Memorandum

To: Brad Walters, El Paso County
From: Andrew W. McCord, P.E.
Date: January 19, 2021
Project: Glen at Widefield Filing 9
Subject: El Paso County Concerns from January 14, 2021 Field Inspection

O 19 **EMERGENCY SPILLWAY**
SCALE: NTS

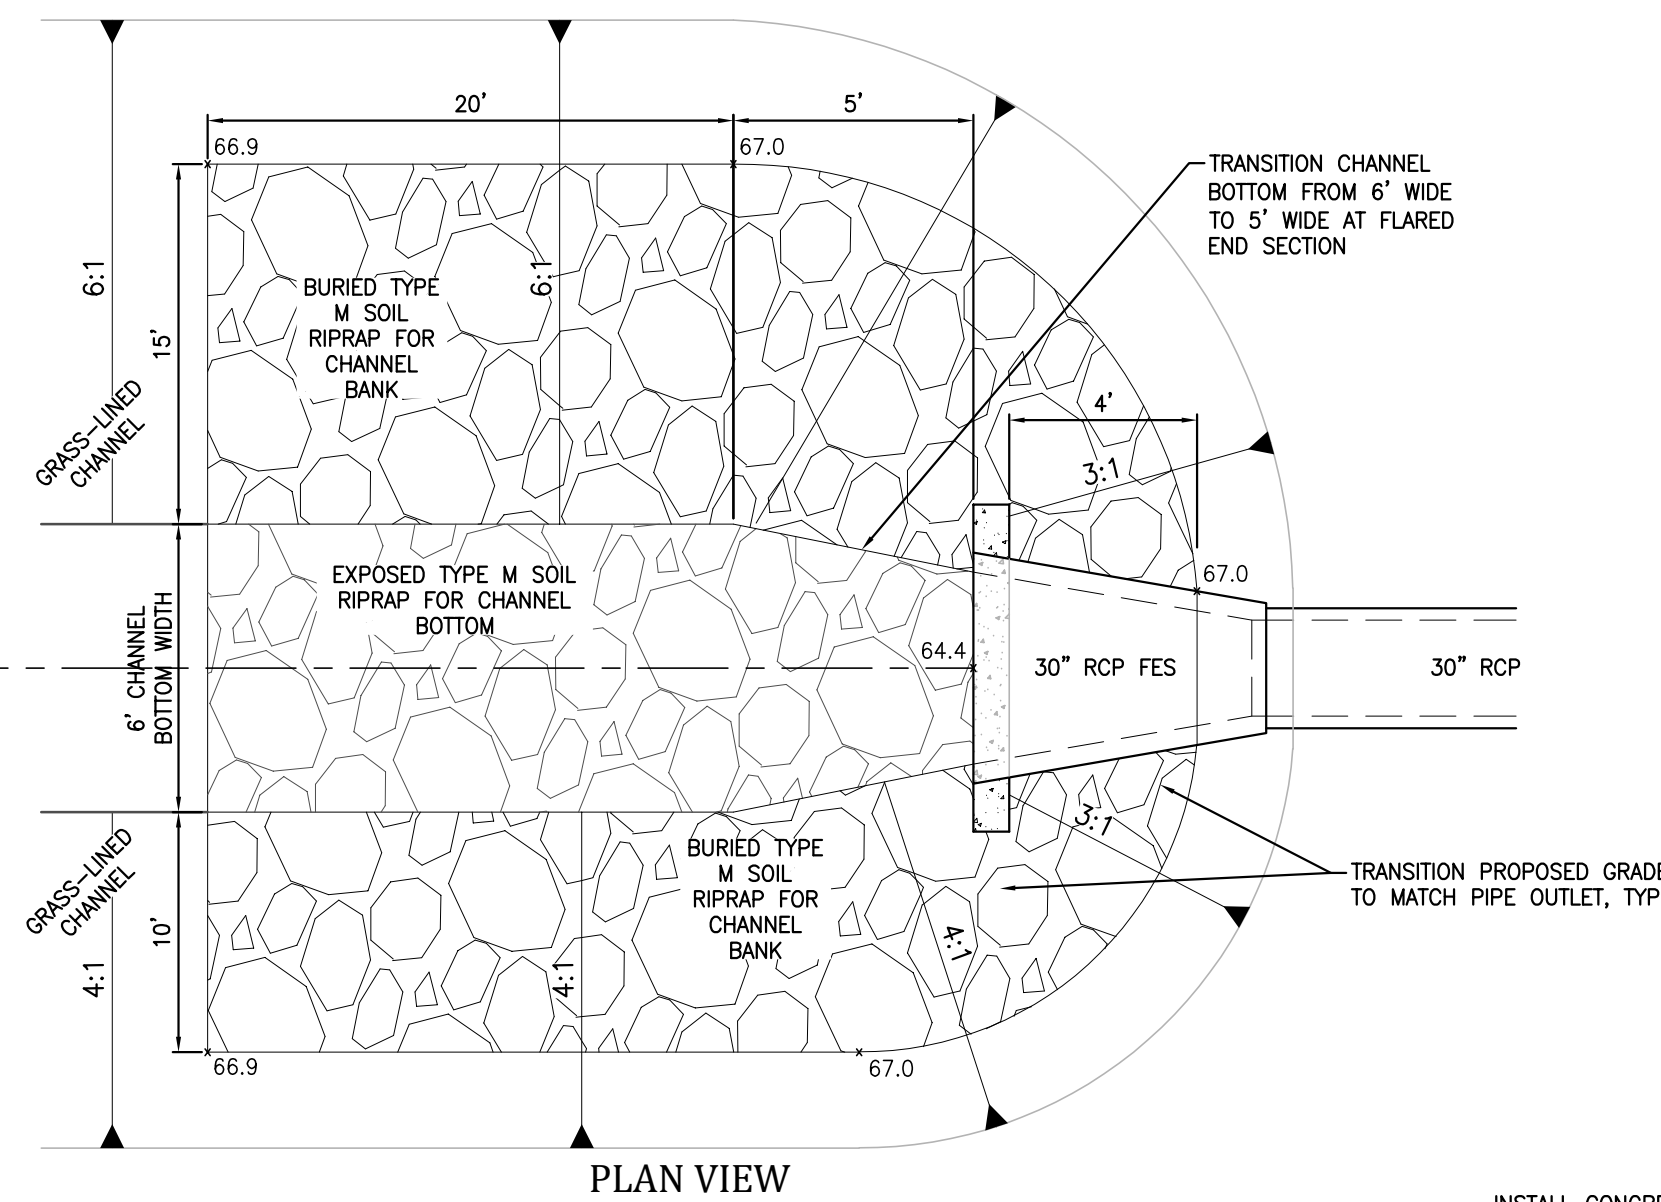
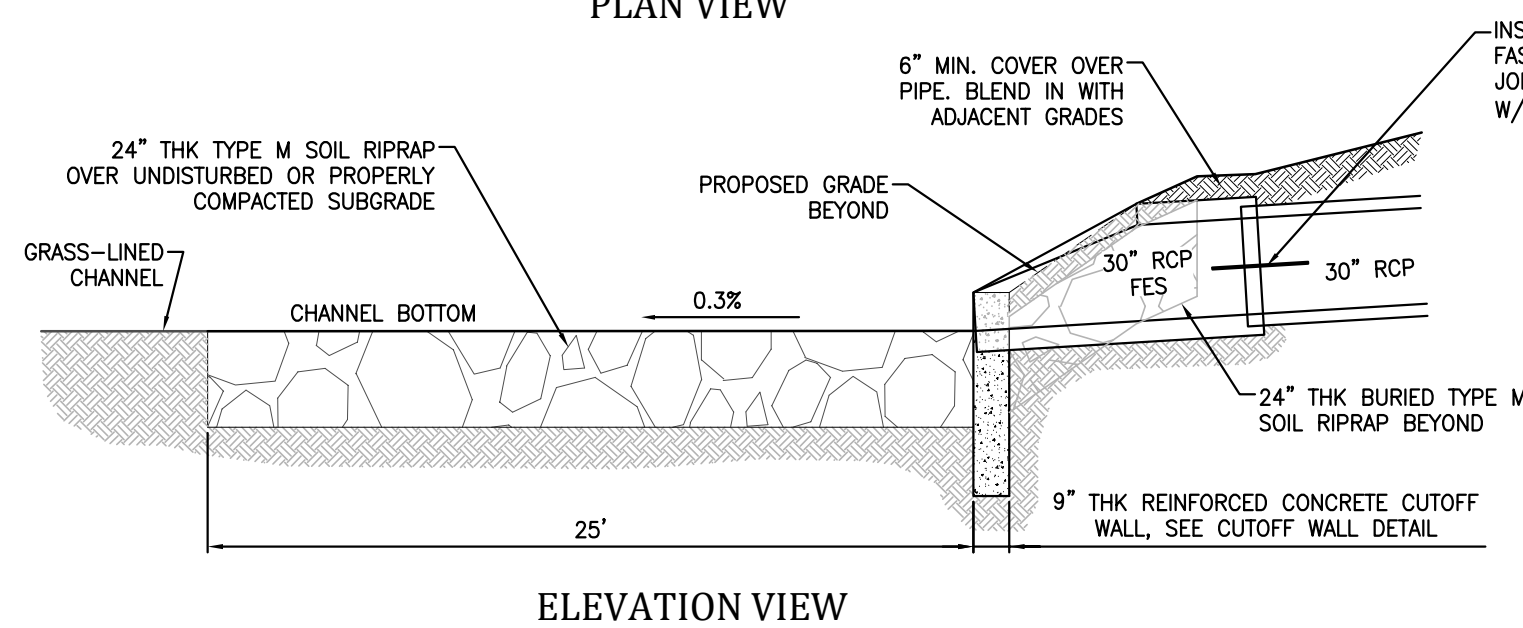
1. Detention Basin Emergency Spillway Width

- A. Original approved plans call for a spillway length of 66 feet on plan sheet 18, Detail O/19. The 66-foot dimension was labeled incorrectly and should be 15 feet in accordance with the approved Drainage Report (see Exhibit 1).

D 19

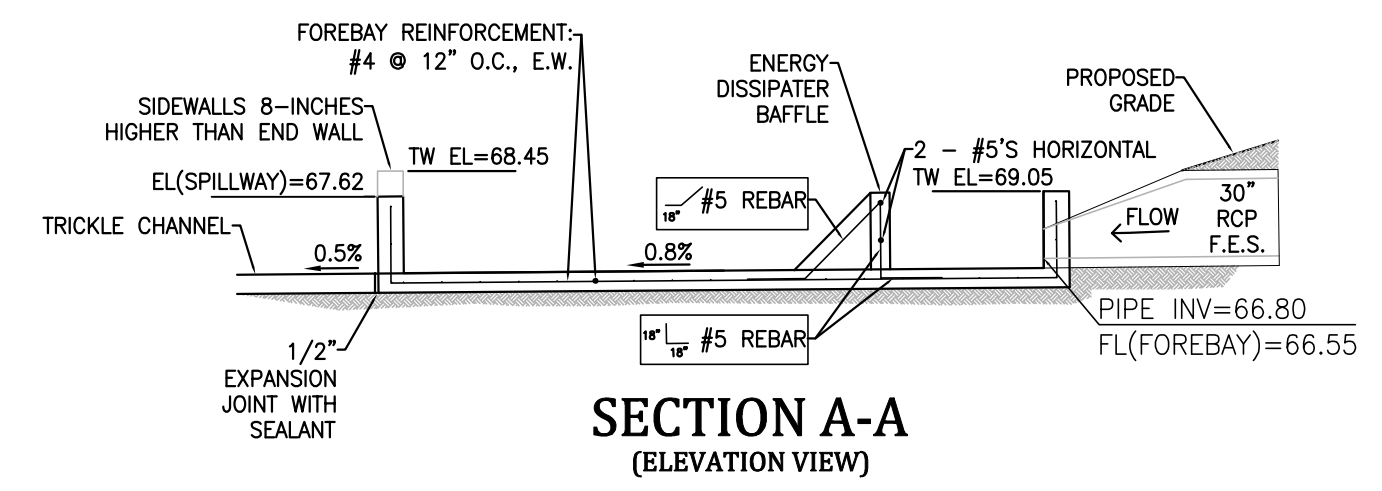
3. Buried Riprap at 30-inch Detention Basin Outlet

- A. Original approved plans call for “EXPOSED TYPE M SOIL RIPRAP FOR CHANNEL BOTTOM” on plan sheet 18, Detail D/19. The word “EXPOSED” is incorrect and should be eliminated. Soil riprap is buried and not exposed. Existing field condition is correct.
